From:
To: [David Wordsworth](#)
Cc: [DCAdmin](#)
Subject: Planning application for 42 dwellings on Lingards Road - 2020\93954
Date: 20 September 2022 13:24:05

I am writing to you in the absence of Mr. Hirst with regard to a few recent queries regarding the Lingards Road development. I am unsure of the process regarding community comments on formal consultations that have recently been received so I hope this is ok.

House Type A1.

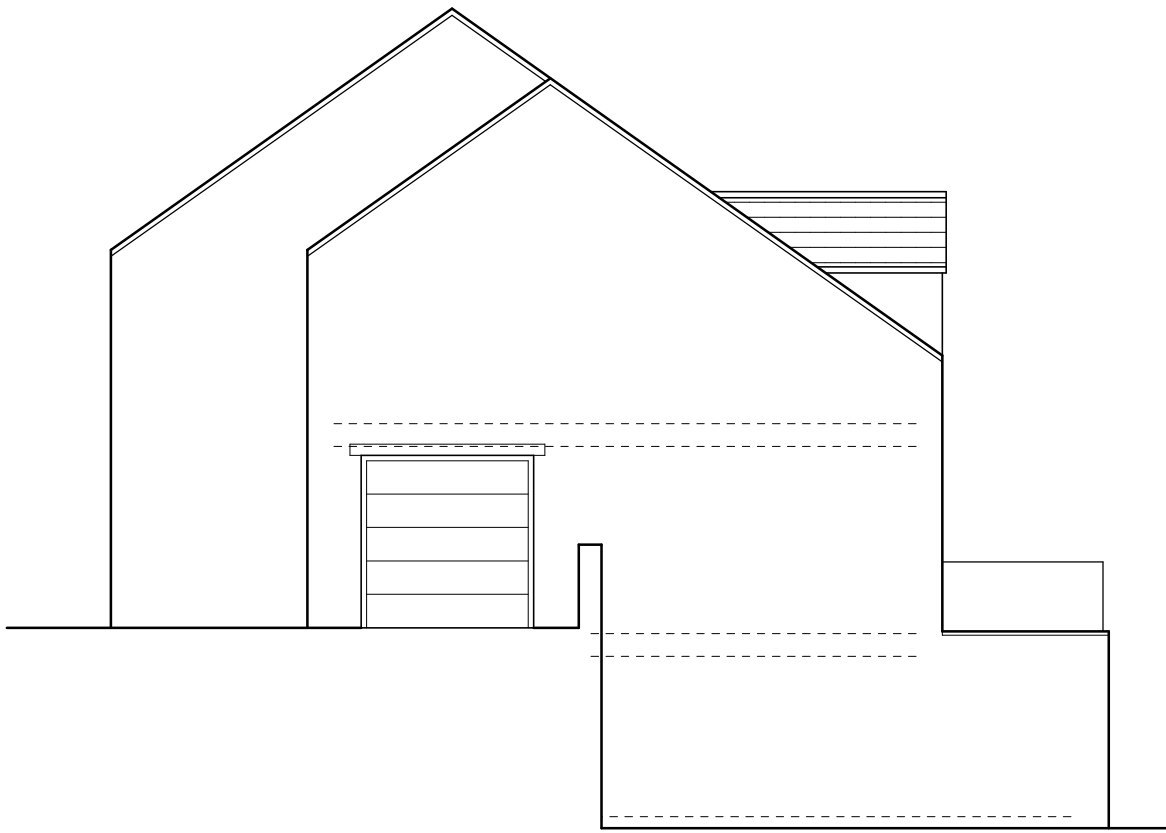
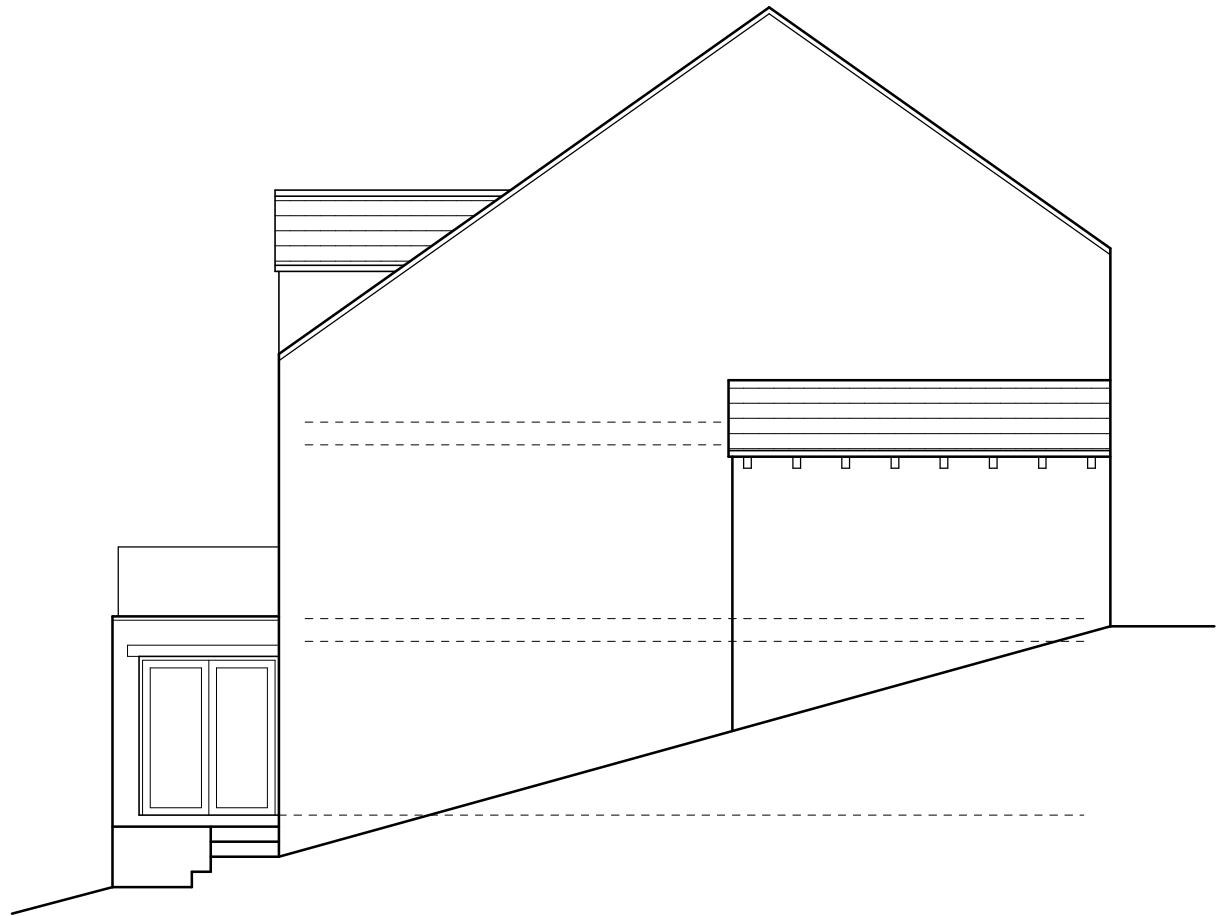
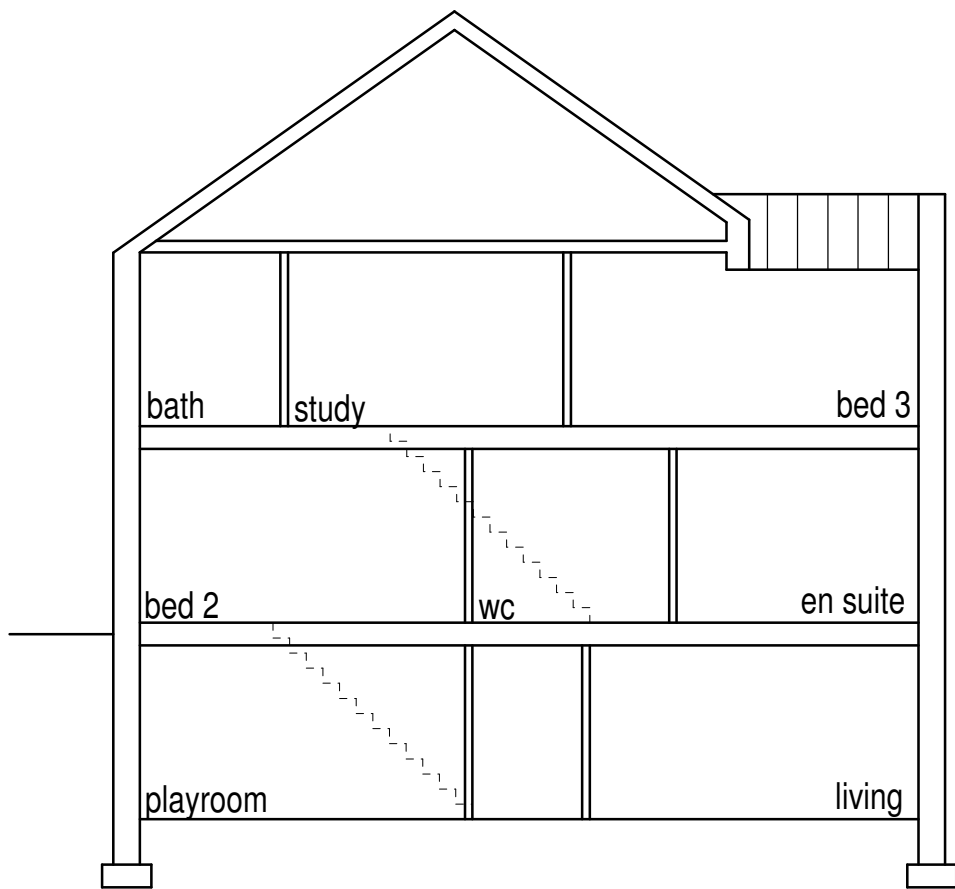
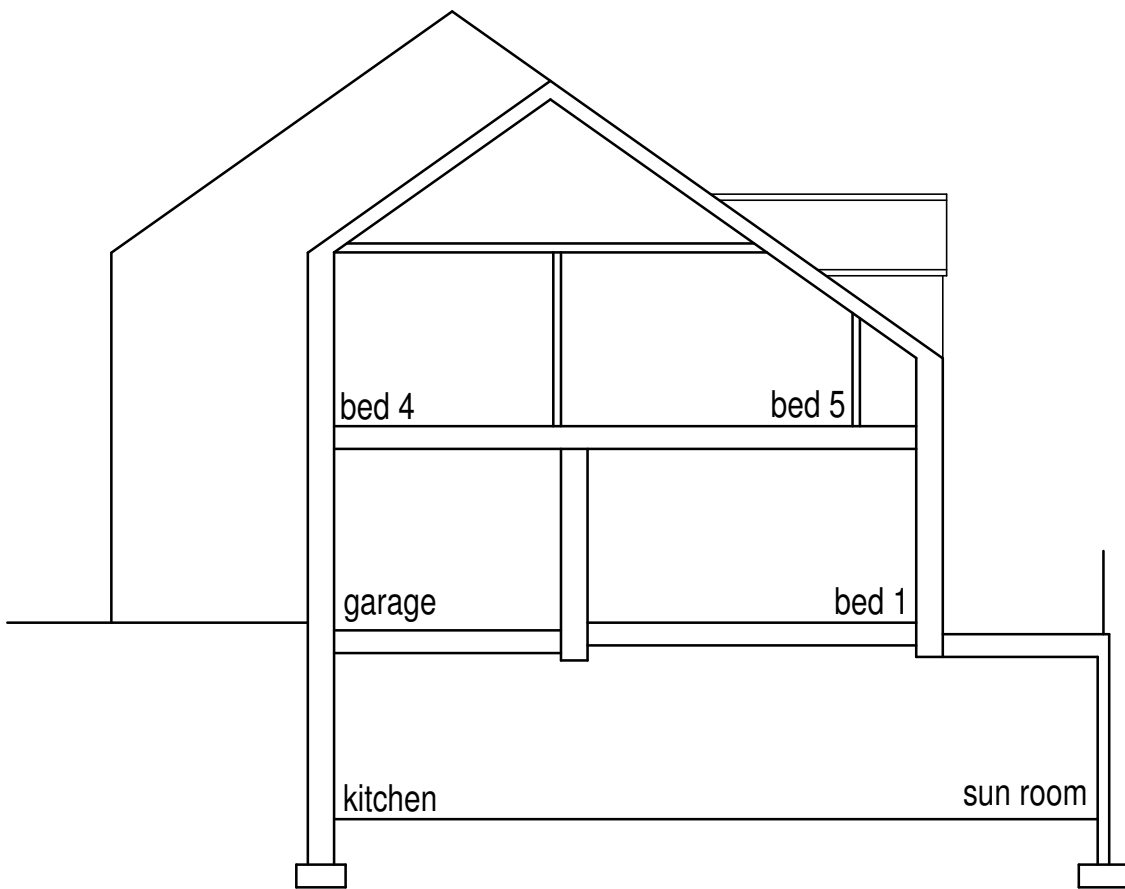
Whilst the new dwellings are detached or semi, they are most definitely not 1 or 2 storey. most are 3 storey with a roof positioned on platforms on a steep slope . This is a major concern to us; the enormity of the dwellings is further shown on the newly submitted 3D images dated 09.06.22, where the scale in relation to the existing neighbourhood houses can clearly be seen. Therefore I am unsure as to how these very large houses can be seen to reflect the houses around the area or any part of Slaithwaite.
